CITY OF ALBUQUERQUE

**Re: Sonata Green Apartments - Tree Line Ave @ Universe Blvd NW
Erosion and Sediment Control Plan
Engineer's Stamp Date 9/14/2020 (C10E001A)**

ESC-1

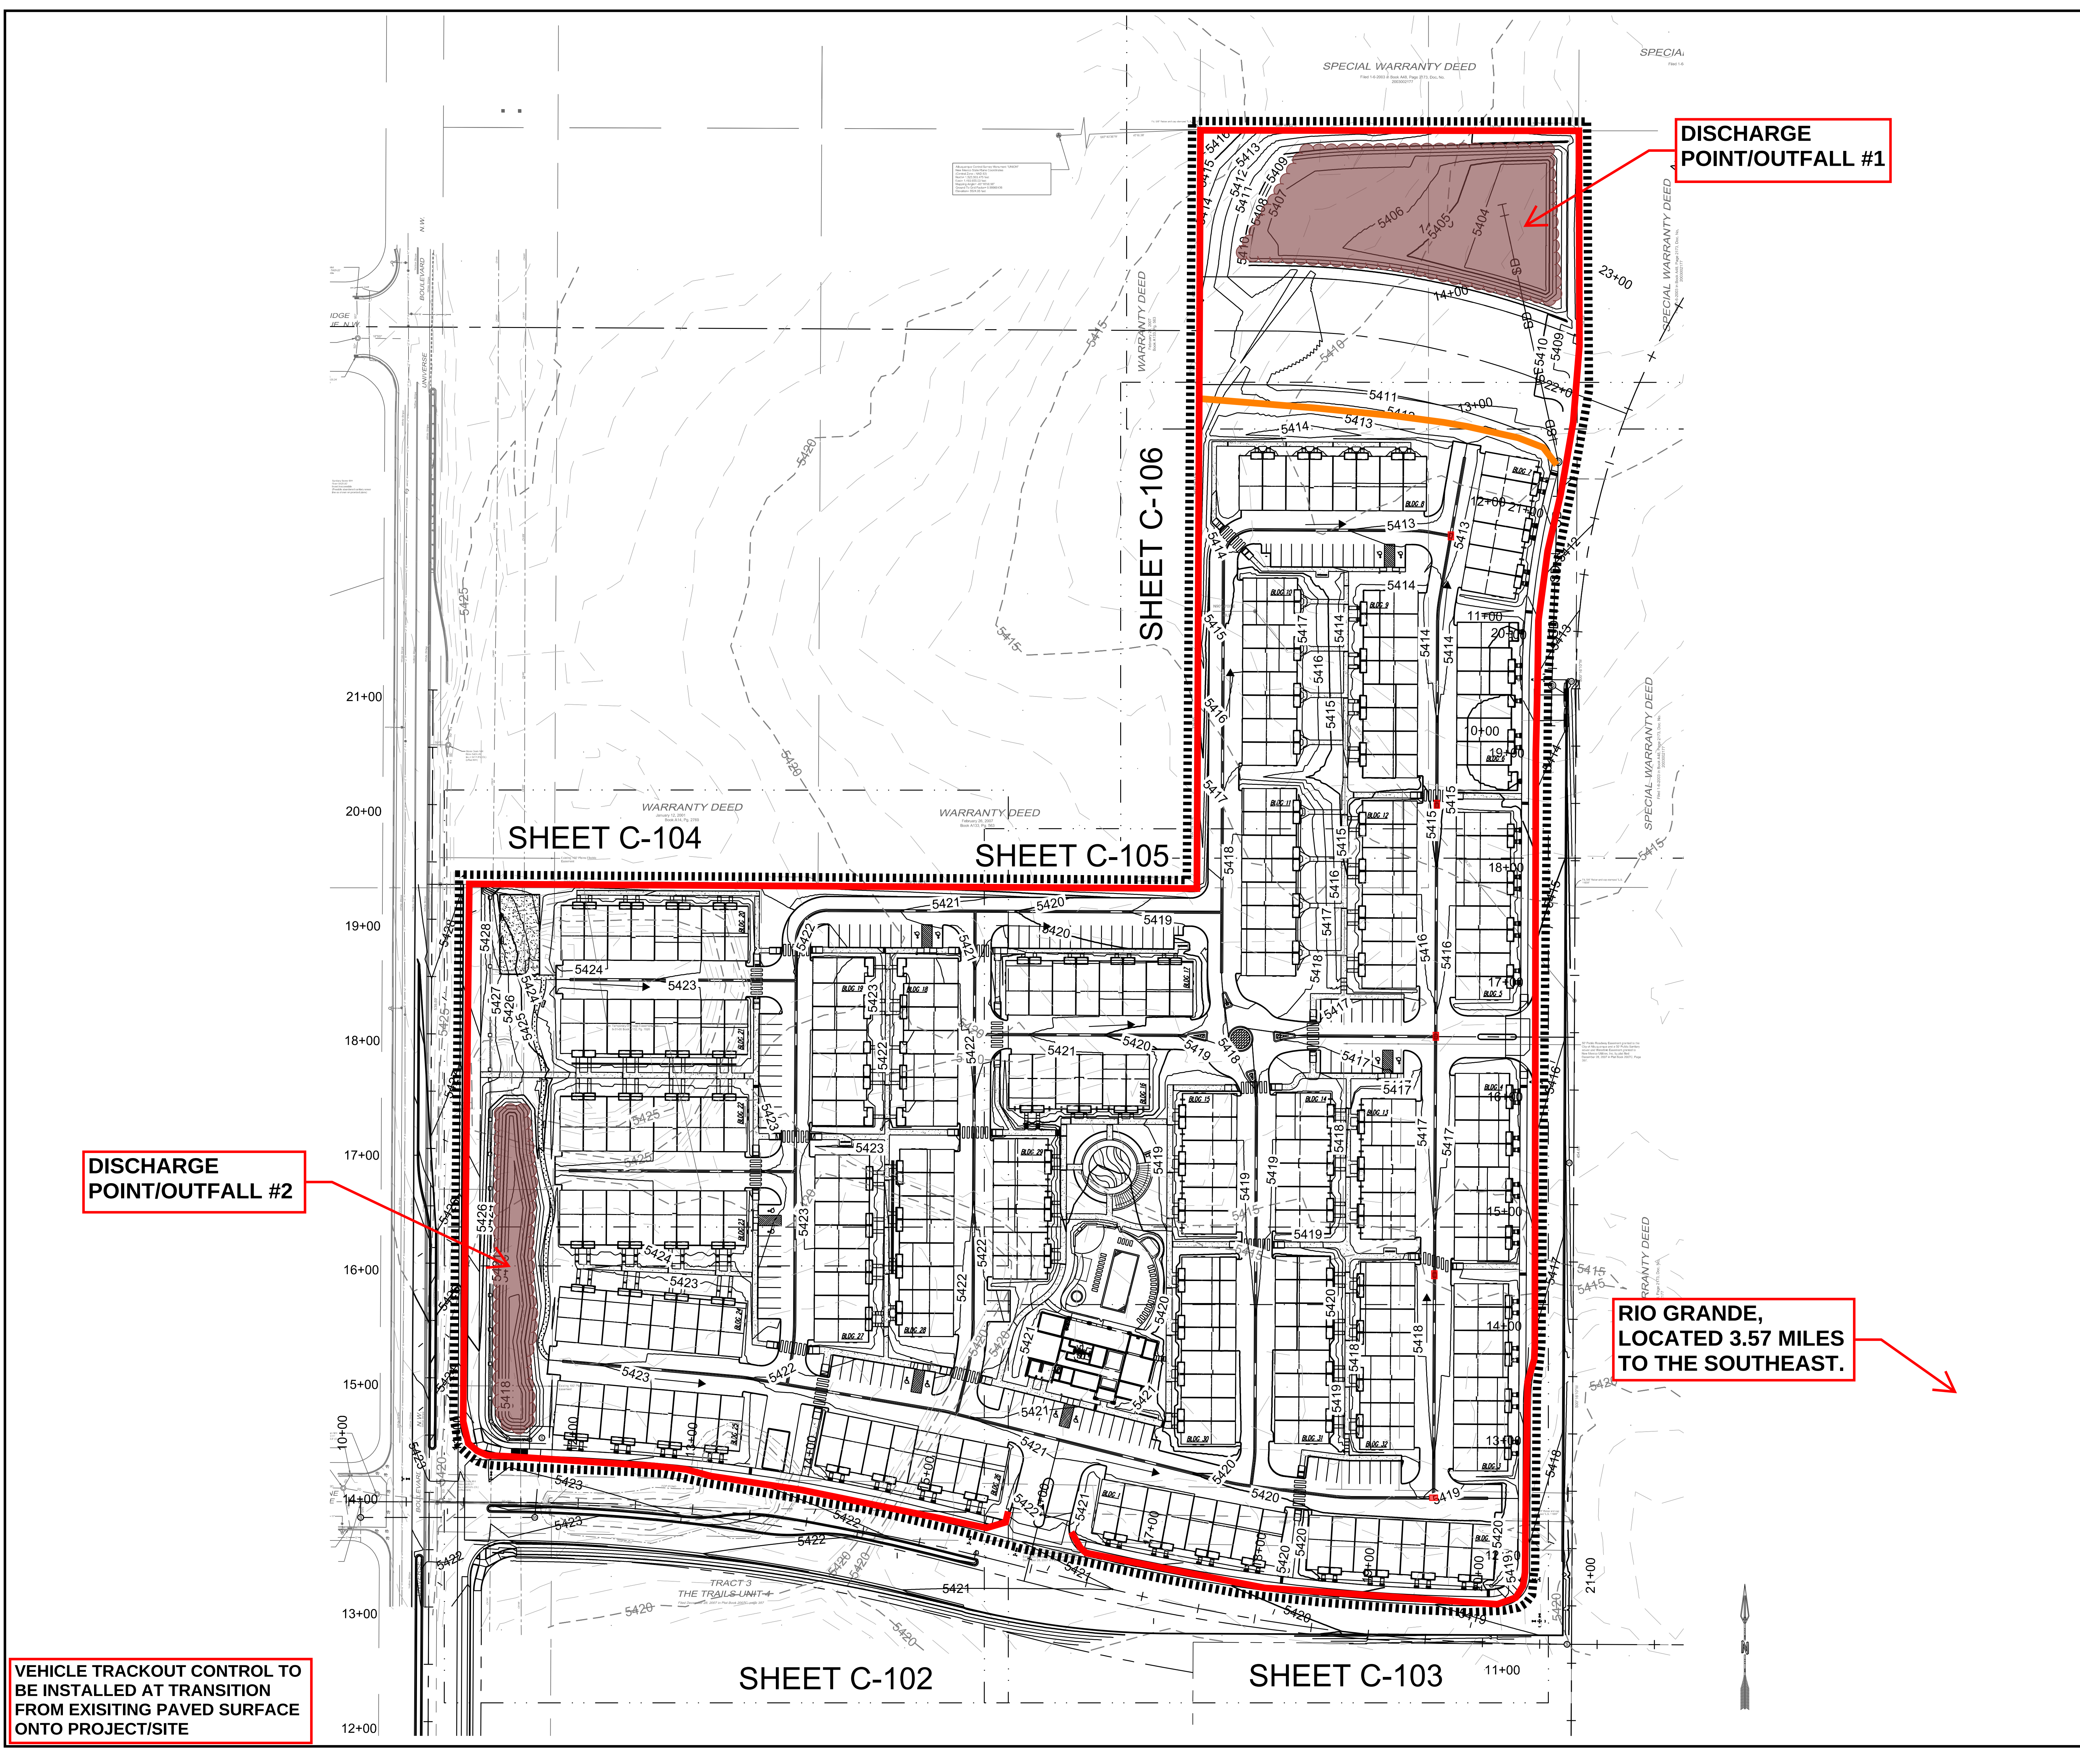
1. A comprehensive plan is needed. The site shown is part of a larger common plan of development that includes the construction of adjacent streets south and east of the apartment site. Identify controls for the adjacent streets and identify which operator will be responsible for NPDES compliance in those areas. State on the plan whether or not there will be a separate SWPPP for that area?

2. Silt fence alone is not sufficient, especially for diverting onsite flows to the sediment ponds and for diverting offsite flows around the construction site. Show on the plan how the offsite flows draining into this construction site from the west and east will be handled, and account for those areas in the design calculations.

3. Provide build notes, details, and design calculations for sediment traps, sediment basins and diversion berms/swales. The build notes should state that these controls must be the first item of construction and must precede clearing and grubbing operations on the rest of the site.

5. Please add the following City Standard Notes to the plan.
